## NeW Space – Detailed Response to Submissions

DRAWING TITLE
CONSERVATORIUM
CAR PARK

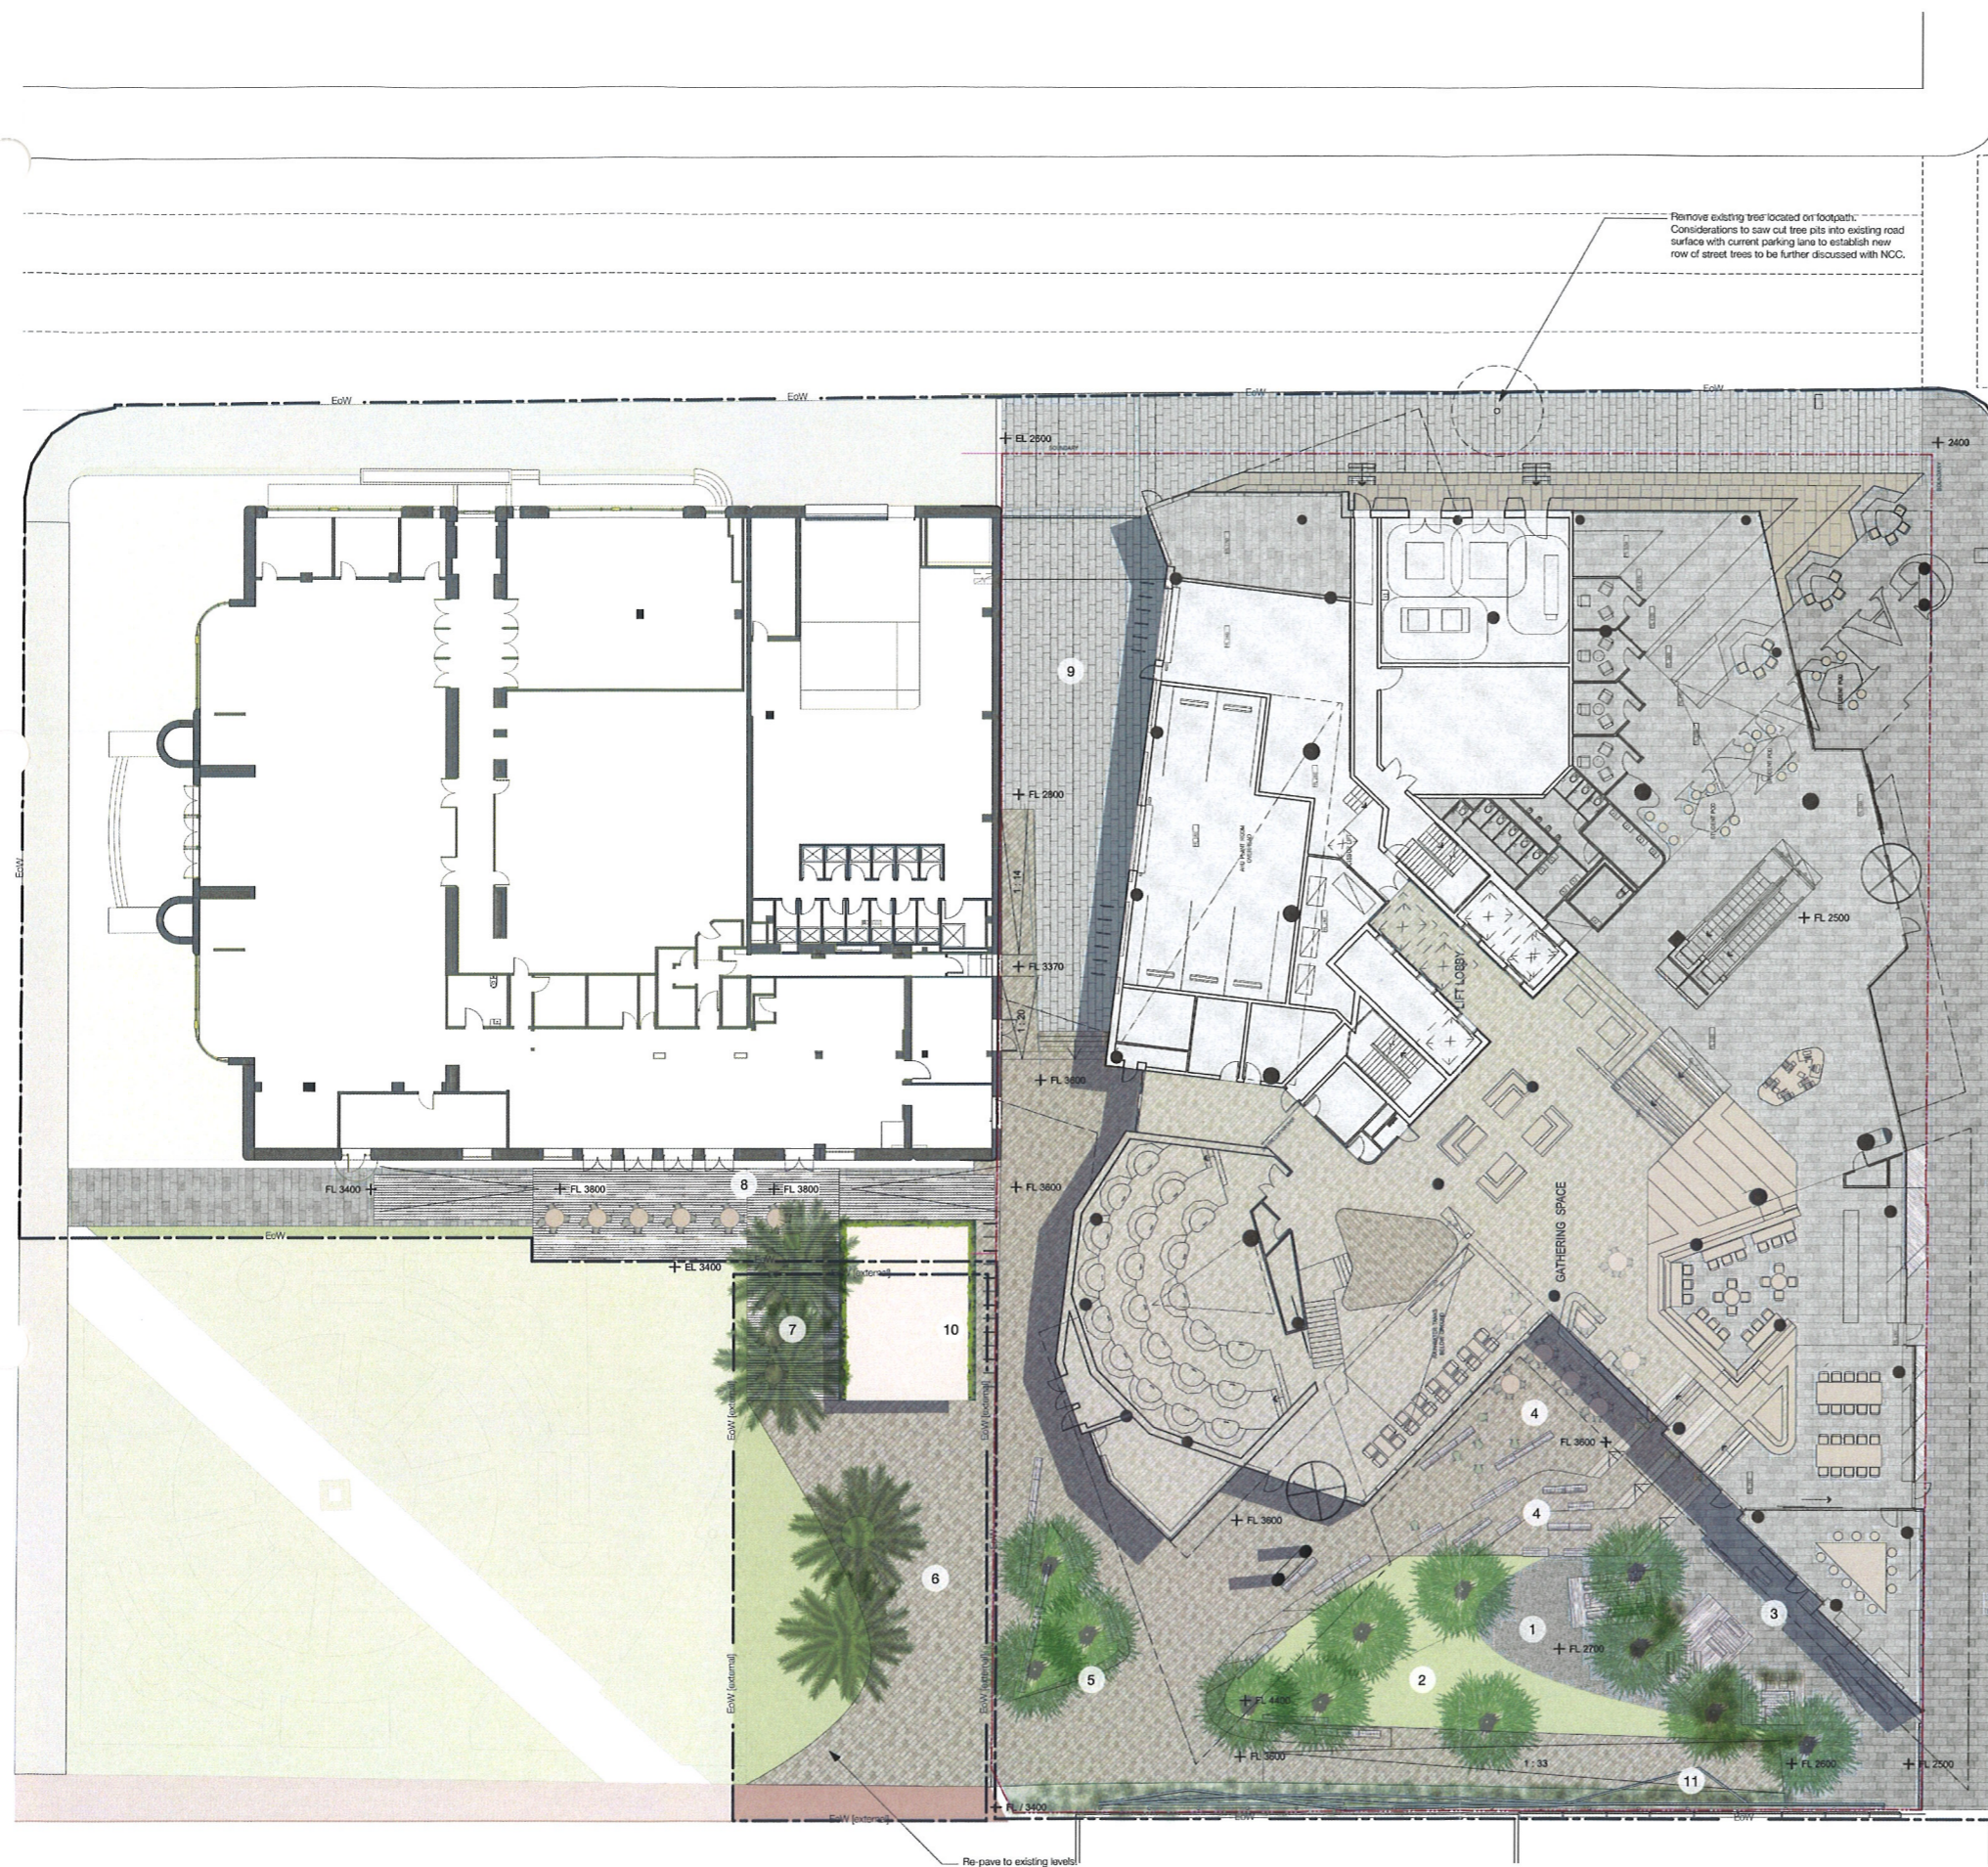
<b>Local Planning Instruments and Controls.</b>	<p>The car park between Gibson and Laman Streets is zoned R3 Medium Density Residential and is permissible in the zone. It is not considered to be consistent with the zone aims and objectives. The upgrading of the car park entrenches the non-residential land use of the site and does not meet the strategic direction of the Newcastle LEP 2012 for this location.</p> <p>Appendix J of the EIS contains a variation request pursuant to clause 4.6 of the Newcastle LEP 2012 seeking to justify a contravention of the maximum building height of 49.1 m permitted on the New Space site. The request incorrectly indicates that the request has been made in support of a development application submitted to Council.</p> <p>The EIS has not considered relevant sections of the DCP including the following:</p> <ul style="list-style-type: none"> <li>- Section 5.07 -Heritage Conservation Areas</li> <li>- Section 7.03- Traffic, Parking and Access</li> </ul>	<p>The proposed car parking use is consistent with the relevant objectives of the zone as it:</p> <ul style="list-style-type: none"> <li>▪ constitutes a land use that provide car parking facilities to meet the day to day needs of residents from the Newcastle LGA and surrounds; and</li> <li>▪ contributes to the diversity of activities in the locality.</li> </ul> <p>Noted. The Clause 4.6 Variation Request is no longer sought as the proposal has been redesigned to be within the maximum height limit of the Newcastle LEP 2012.</p> <p>The relevant provisions of the Newcastle DCP 2012 are addressed where required. As noted by Council, the Newcastle DCP 2012 does not apply to the project as it is deemed to be State Significant Development.</p>
